Lime Down Solar Park – Development Consent Order (DCO) Application

Environment Agency Examination Deadline 5 Response: Responses to the Examining Authority's Second Written Questions, Comments on documents submitted at Deadline 4 and Standard Protective Provisions

Title:
Figure 11.5 Rev 4: Lime Down D (BESS)
Fluvial and Surface Water Flood Risk Map

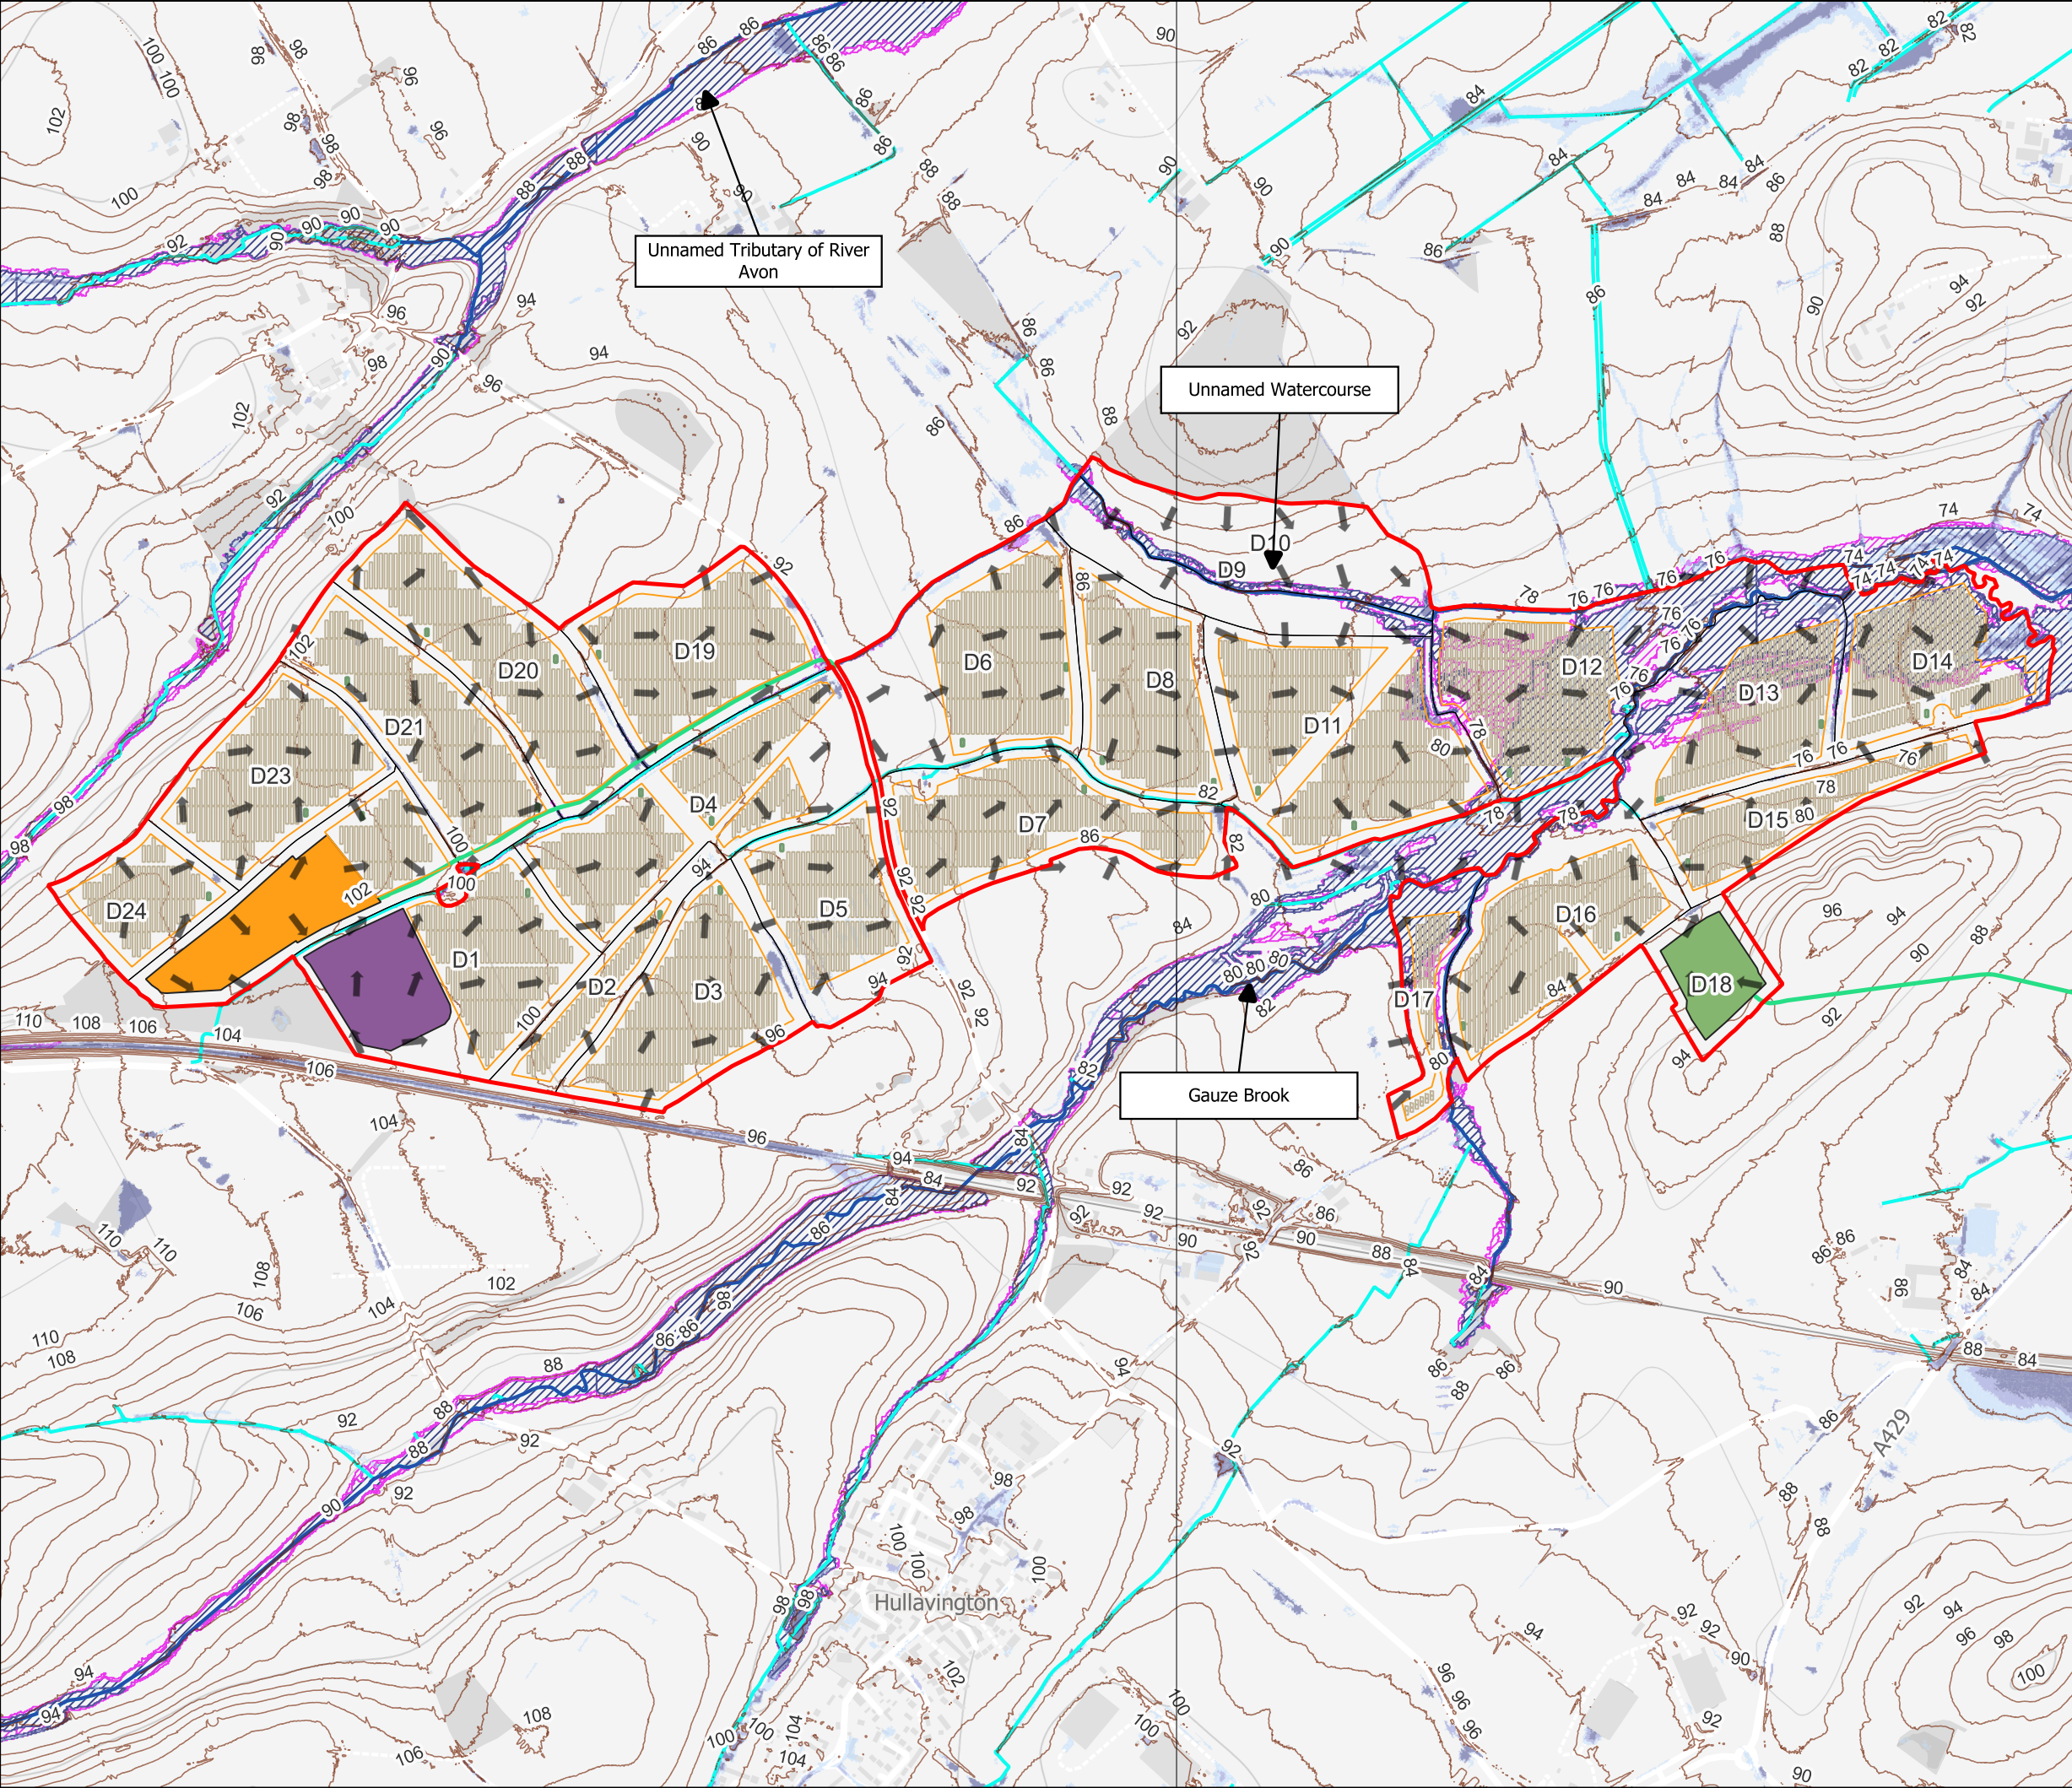
FHW2.3	The Environment Agency The Lead Local Flood Authority	Flood Risk Assessment – Hydraulic Modelling The EA, in its hearing submission [REP4-097], explains that for Lime Down D modelling there are unresolved issues regarding the data used and missing information and requests further information from the applicant. The applicant submitted at deadline 4 the hydraulic modelling report for Lime Down E2 [REP4-089]. <u>The Environment Agency:</u> 1) Can the EA confirm if all the required further information for Lime Down D modelling has been submitted? 2) Can the EA please provide an update of the review of the hydraulic modelling for Lime Down E2 at deadline 5 confirming if further information is required and highlighting any significant issues found? <u>The LLFA:</u> 3) Considering the EA response to ExQ1 FWM1.4 (2) [REP3-146], the outputs from the applicant's Gauze Brook and Rodbourne Brook modelling which include the 3.33%	1) We have undertaken a review of the applicant's hydraulic modelling for the Gauze Brook, which passes through the Lime Down D site. During our review, we requested that the applicant simulate the 3.3% (1 in 30) annual exceedance probability (AEP) event to define the extent of the functional floodplain (Flood Zone 3b). We also raised technical comments on the model itself relating to riverbank elevations within the model and the representation of the South Wales Main Line culvert. The applicant has subsequently simulated the 3.3% (1 in 30) AEP event and updated the hydraulic modelling report to include mapping of the corresponding flood extent. However, we have not yet received updated hydraulic model files for the Gauze Brook (Lime Down D) to enable a detailed review of any changes relating to riverbank representation and the South Wales Main Line culvert. We met with the applicant on 28 July 2026 and understand that they are currently updating and extending the Gauze Brook hydraulic model. Once these updates have been completed, the applicant intends to submit the revised model files to the Environment Agency for detailed review.

ExQ2	Question to:	Question:	Environment Agency Response
		AEP scenario and the evidence presented by the Stop Lime Down report [REP1-176], does this information support an extension to Flood Zone 3b in Lime Down D? If so, to which fields? 4) If your response to question 3 is positive, please explain any potential impact on the sequential and exception tests results. <u>The LLFA:</u> In your response to ExQ1 FHW1.12 [REP3-142] in relation to an ordinary watercourse running between the fields D22 and D1 you requested the applicant to: • Undertake targeted topographic and channel survey of the watercourse corridor. • Provide proportionate hydraulic assessment (or equivalent evidence) to define flood extents, depths, and flow routes.	2) In relation to Lime Down E2, the applicant has submitted hydraulic model files and an associated hydraulic model report for Rodbourne Brook/Gabriel's Well. We are currently reviewing the modelling and supporting documentation. At this stage, we have not identified any significant issues with the modelling. However, our review is ongoing and we will provide detailed comments to the applicant in due course. Appendix 2 sets out our initial comments.
